WEST SUSSEX COUNTY COUNCIL CONSULTATION

TO:	Arun District Council FAO:Ms M Tomalova
FROM:	WSCC - Highways Authority
DATE:	11 March 2021
LOCATION:	Land Adjacent to 10 Second Avenue Bognor Regis PO22 7LJ
SUBJECT:	FP/32/21/PL Two storey, 4 Bed detached dwelling with new access & parking. This site is in CIL Zone 4 & is CIL Liable as new dwelling.
DATE OF SITE VISIT:	n/a
RECOMMENDATION:	Advice
S106 CONTRIBUTION TOTAL:	n/a

Site Plan (scale 1:500)

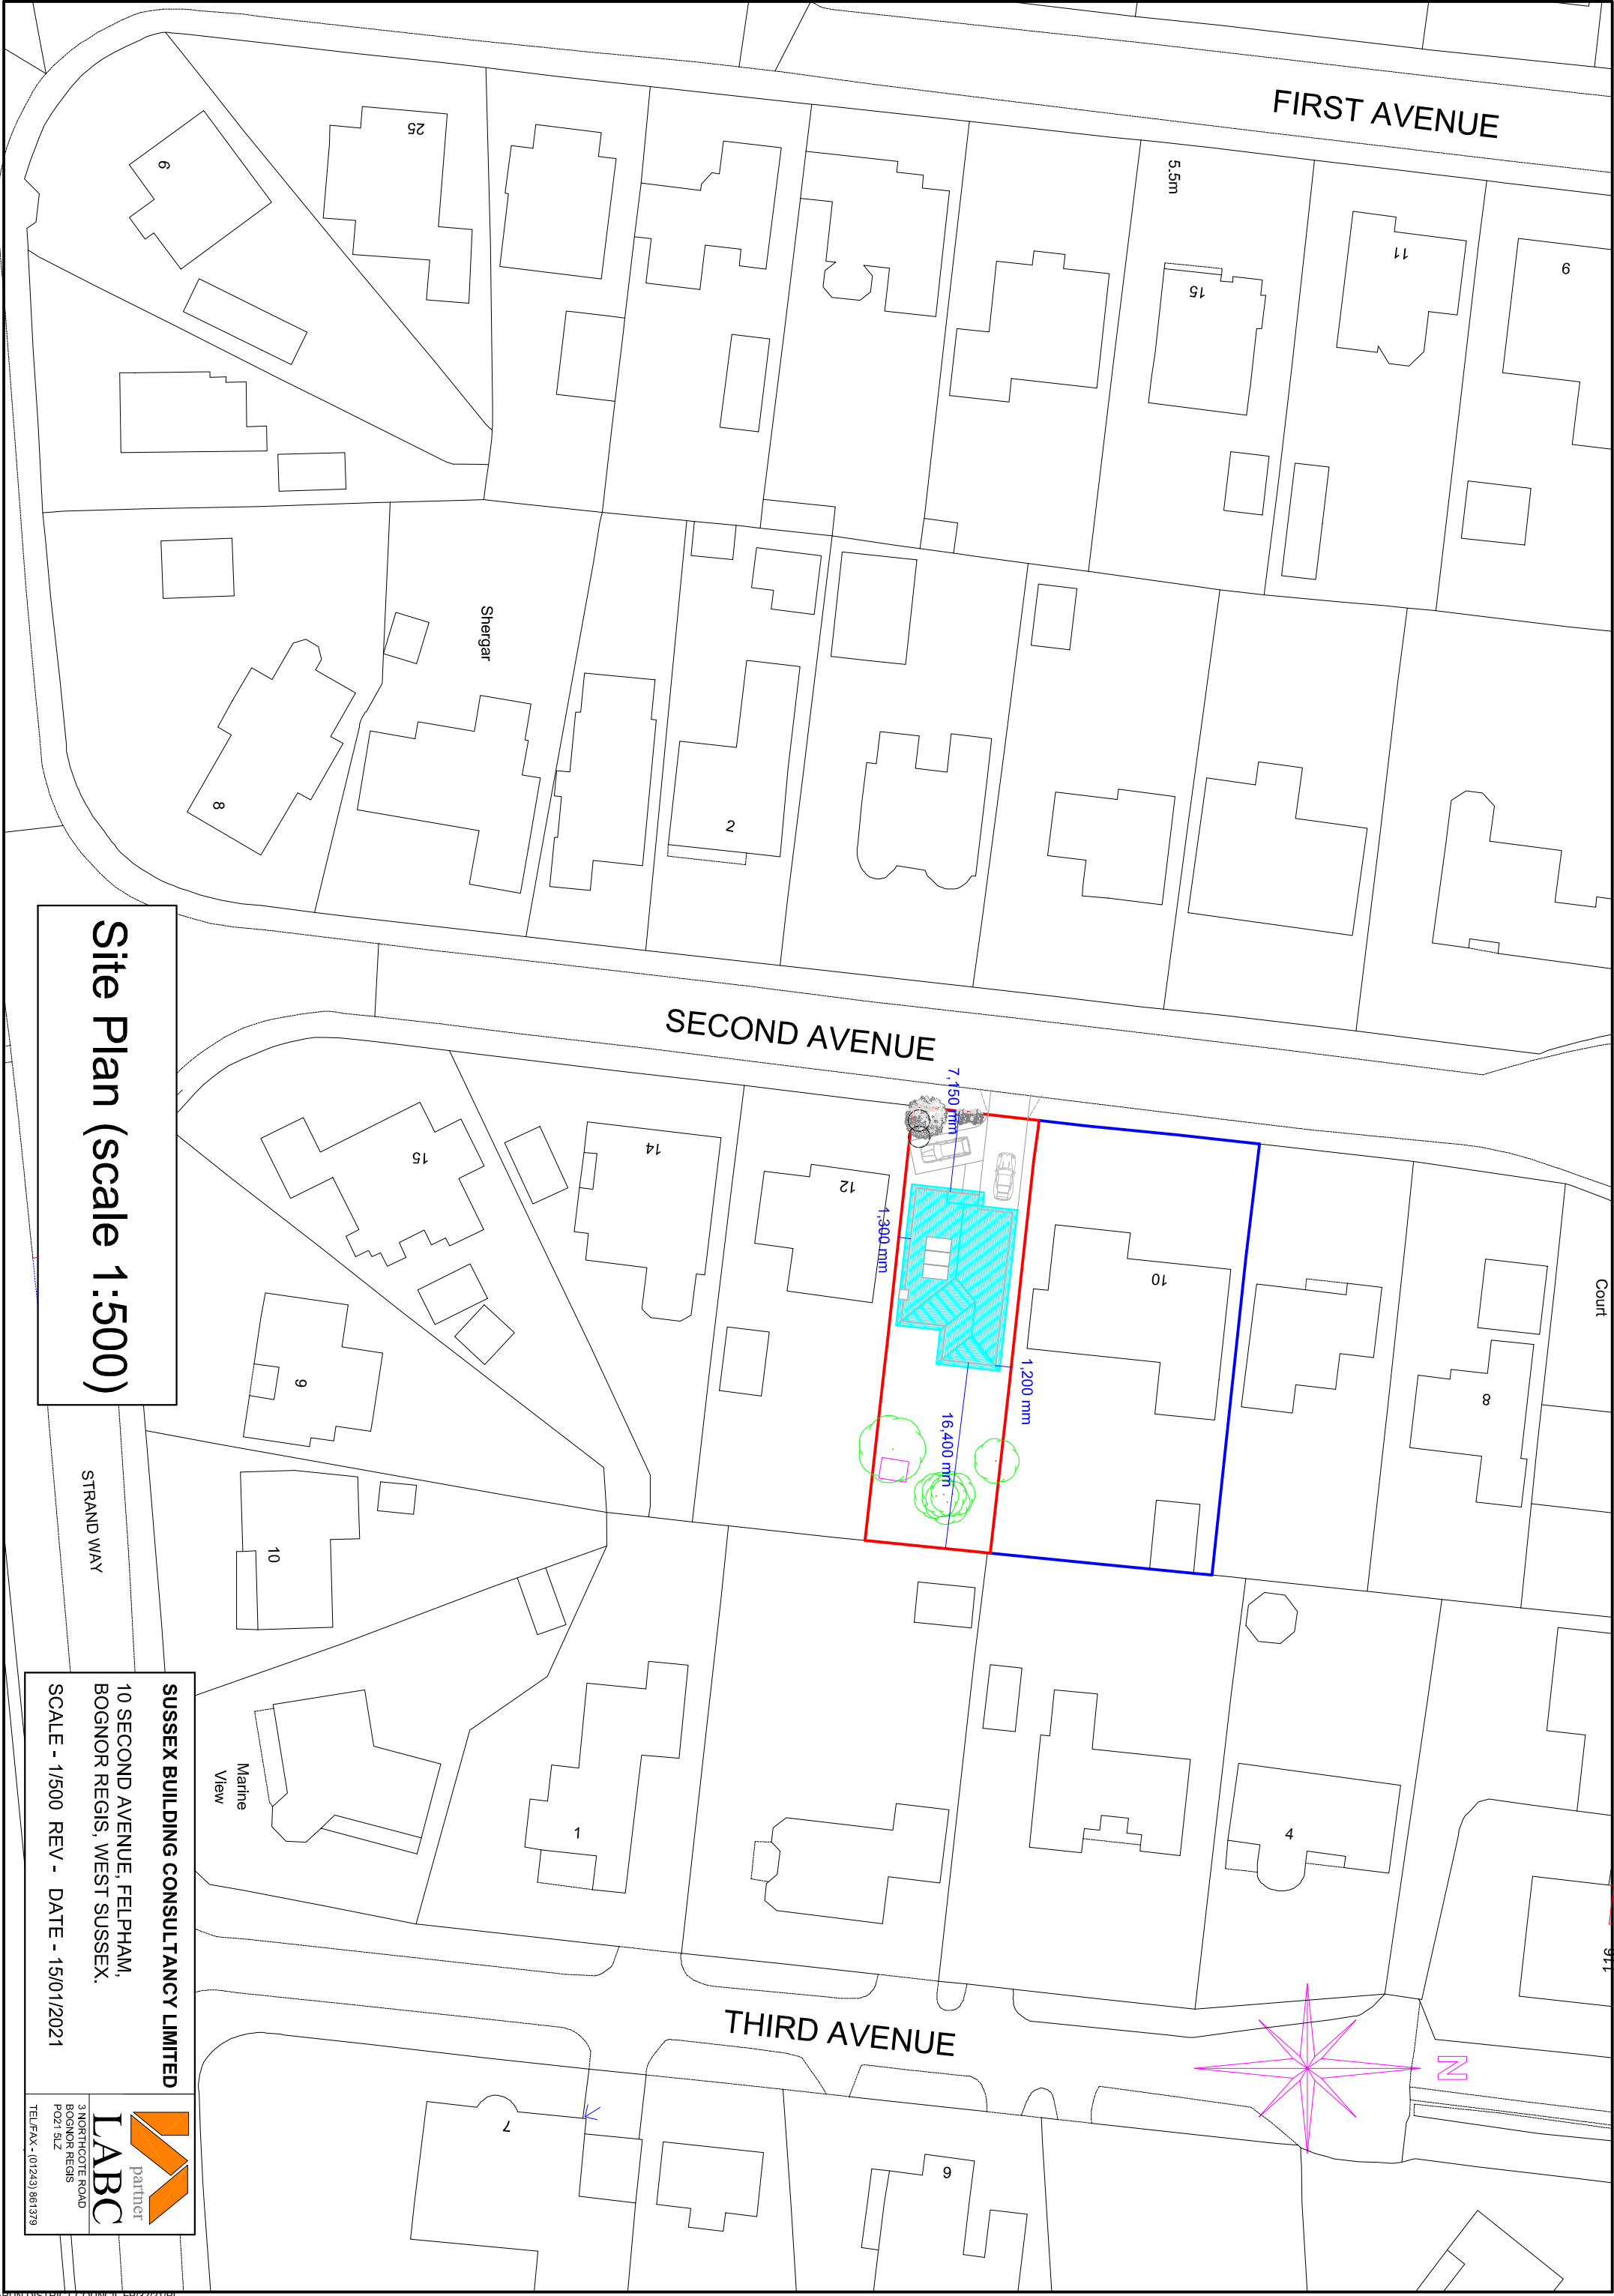
The proposed site plan demonstrates 2 parking spaces to serve the new dwelling. The WSCC Car Parking Demand (PDC) Calculator would expect at least 3 spaces to be provided for 4+ dwelling in this location. The proposed spaces have the adequate dimensions of 2.4 x 4.8m per parking bay. The potential overspill is not anticipated to result in highway safety issue, however the Local Planning Authority (LPA) may wish to assess the impact from an amenity perspective.

In the interests of sustainability and as result of the Government's 'Road to Zero' strategy for at least 50% of new car sales to be ultra-low emission by 2030, electric vehicle (EV) charging points should be provided for all new developments. Active EV charging points should be provided for the development in accordance with current EV sales rates within West Sussex (Appendix B of WSCC Guidance on Parking at New Developments) and Arun Parking Standards (adopted January 2020). Ducting should be provided to all remaining parking spaces to provide 'passive' provision for these to be upgraded in future. Details of this can be secured via condition and a suitably worded condition is advised below.

Car parking space (details approved)

No part of the development shall be first occupied until the car parking has been constructed in accordance with the approved site plan. These spaces shall thereafter be retained at all times for their designated purpose.

No part of the development shall be first occupied until the electric vehicle charging space have been provided in accordance with plans and details to be submitted to and approved by the Local Planning Authority.
